**Consultation Response from KC,
Lead Local Flood Authority**

2024/92281 Land adj, 17, Whitehall Road West, Birkenshaw, BD11 2LS

Erection of 23 dwellings

Date Responded: 24th September 2024

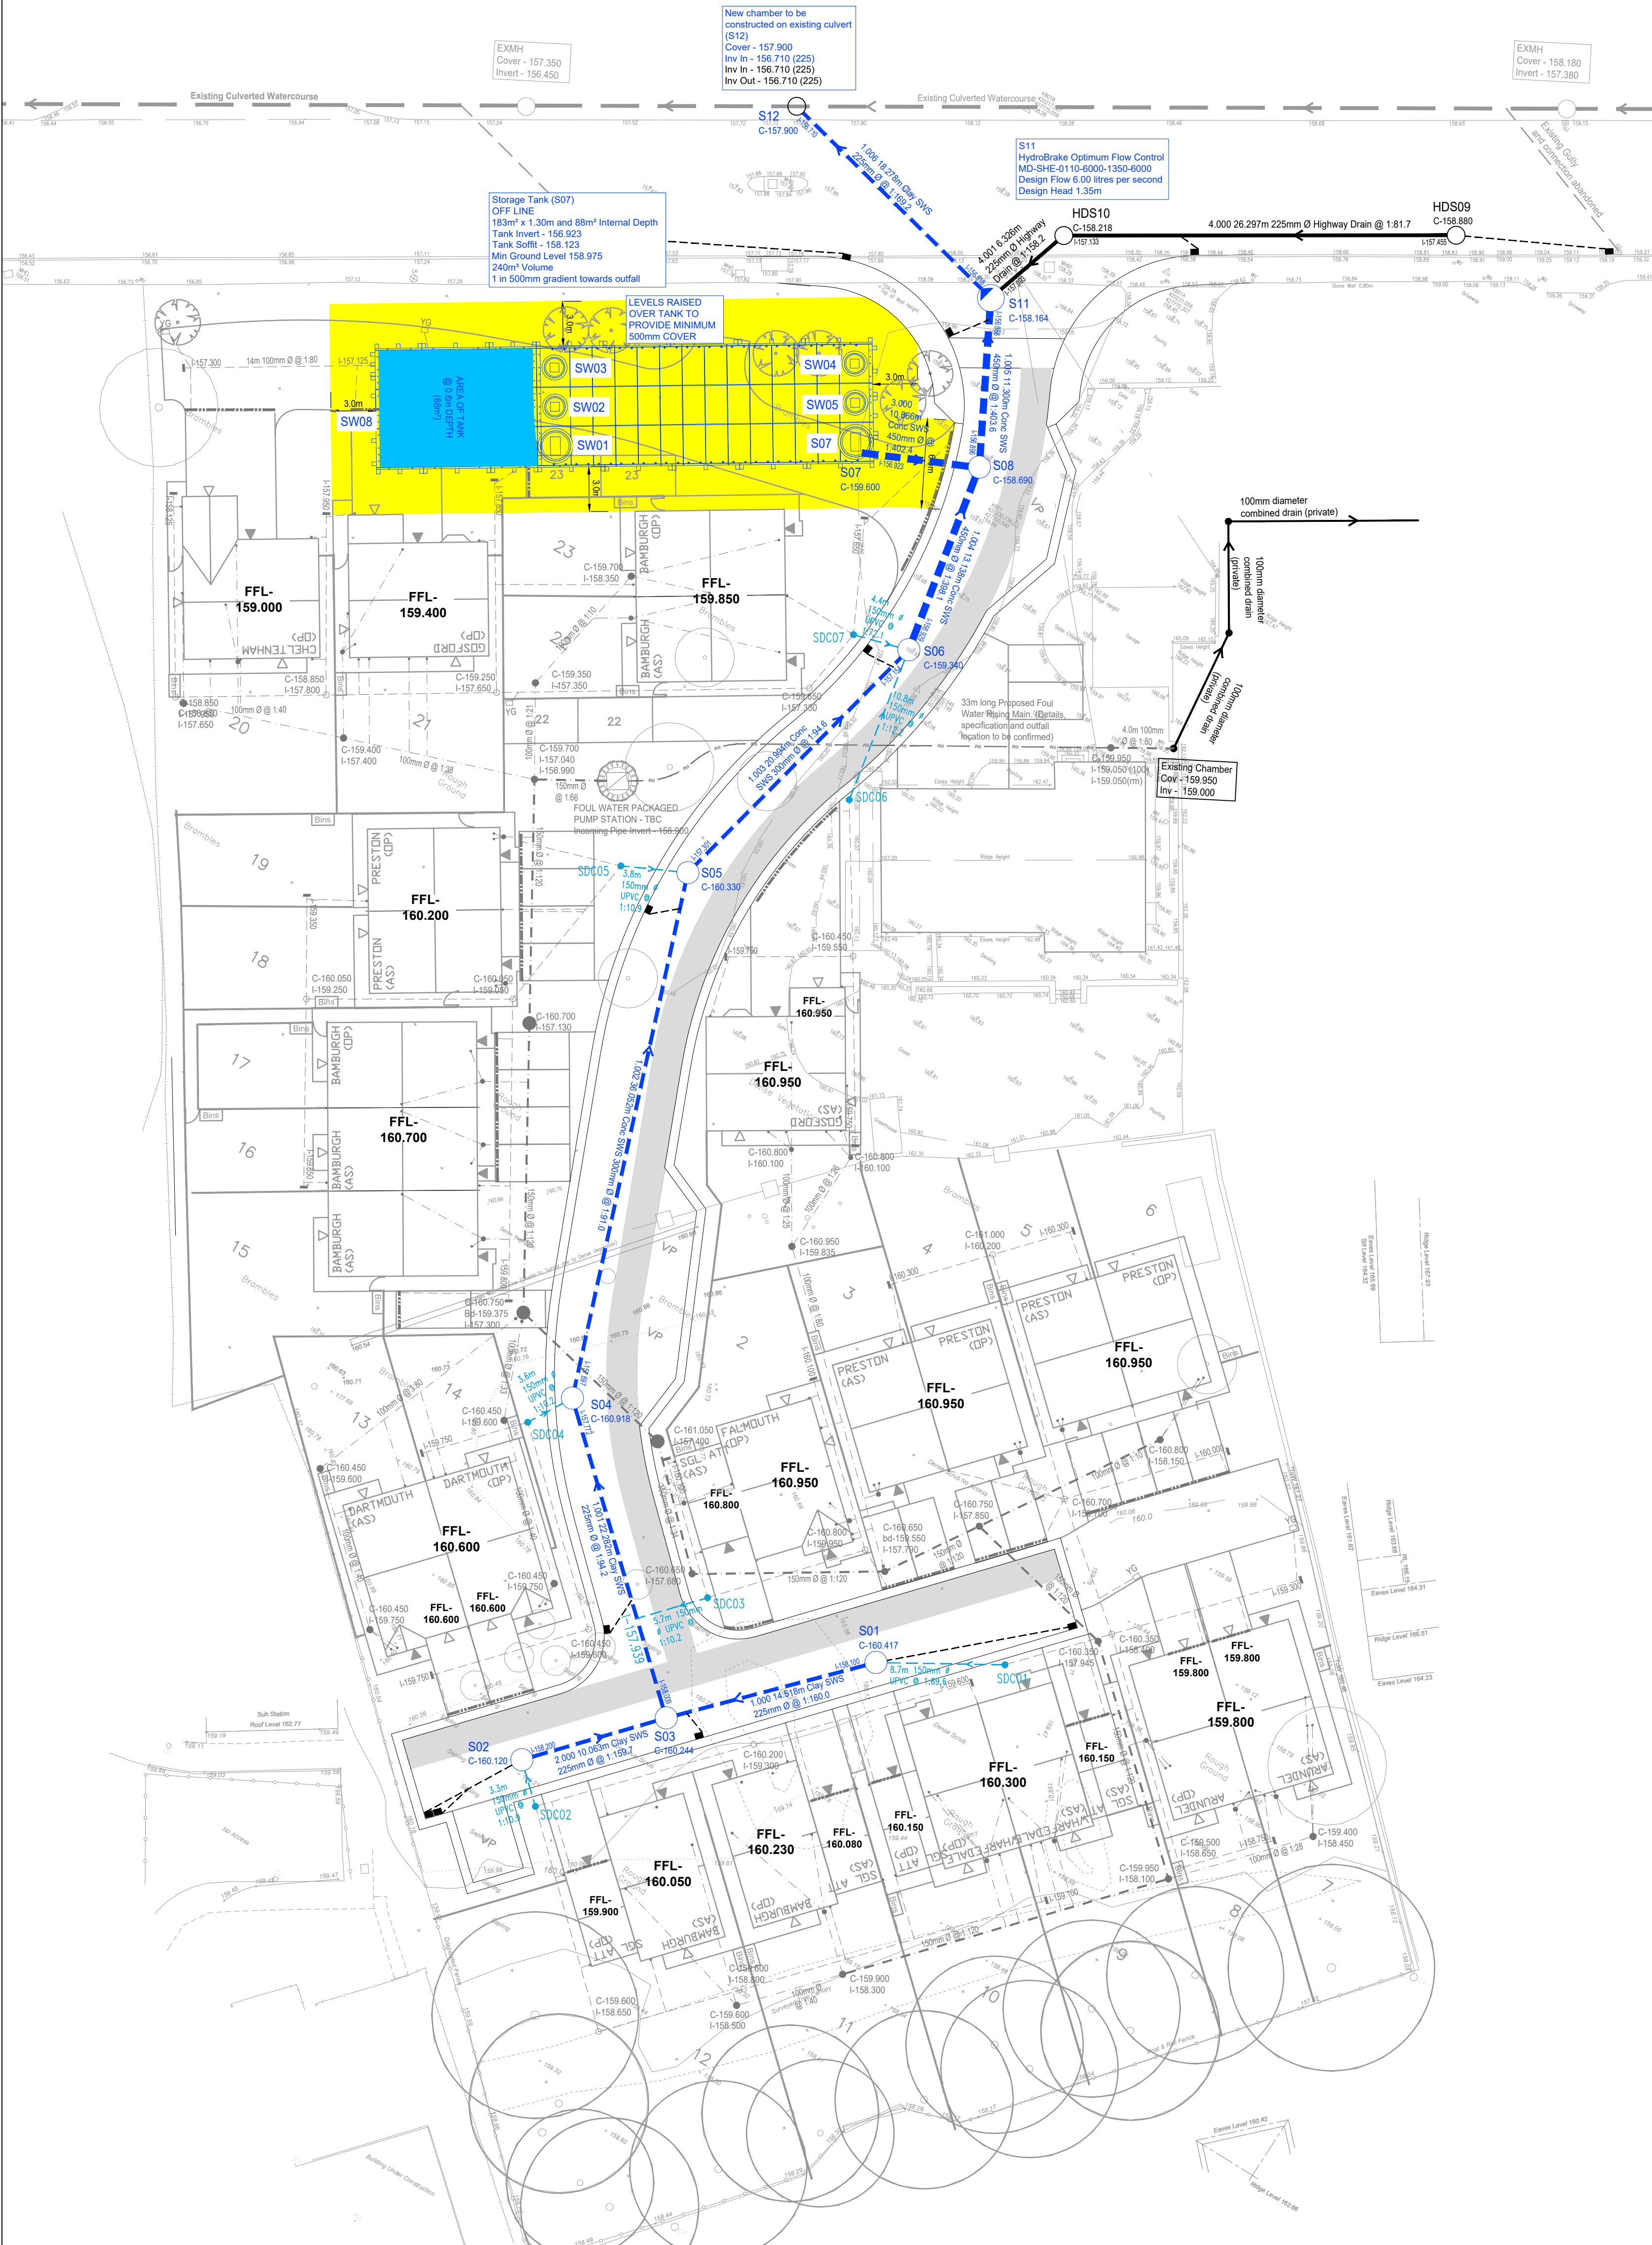
For this application, the amalgamated area is connected to highway drainage in Whitehall Road West. A written justification is required to show that peak flows, that also includes part of the existing highway, clearly demonstrate no increase.

A simulation of rainfall events, 1 in 1, 1 in 30 and 1 in 100 + 45% climate change should be provided and demonstrate no flooding on site and self-cleansing flows.

We are concerned over potential inadequate gradients of pipework and lack of cover over the attenuation tank. As a guideline, 1.2m of cover in trafficked areas and 0.9m of cover in landscaped areas is desirable.

The pump station should be 15metres away from properties to combat odour problems.

Flood routing should be demonstrated and shown to not enter property curtilage.
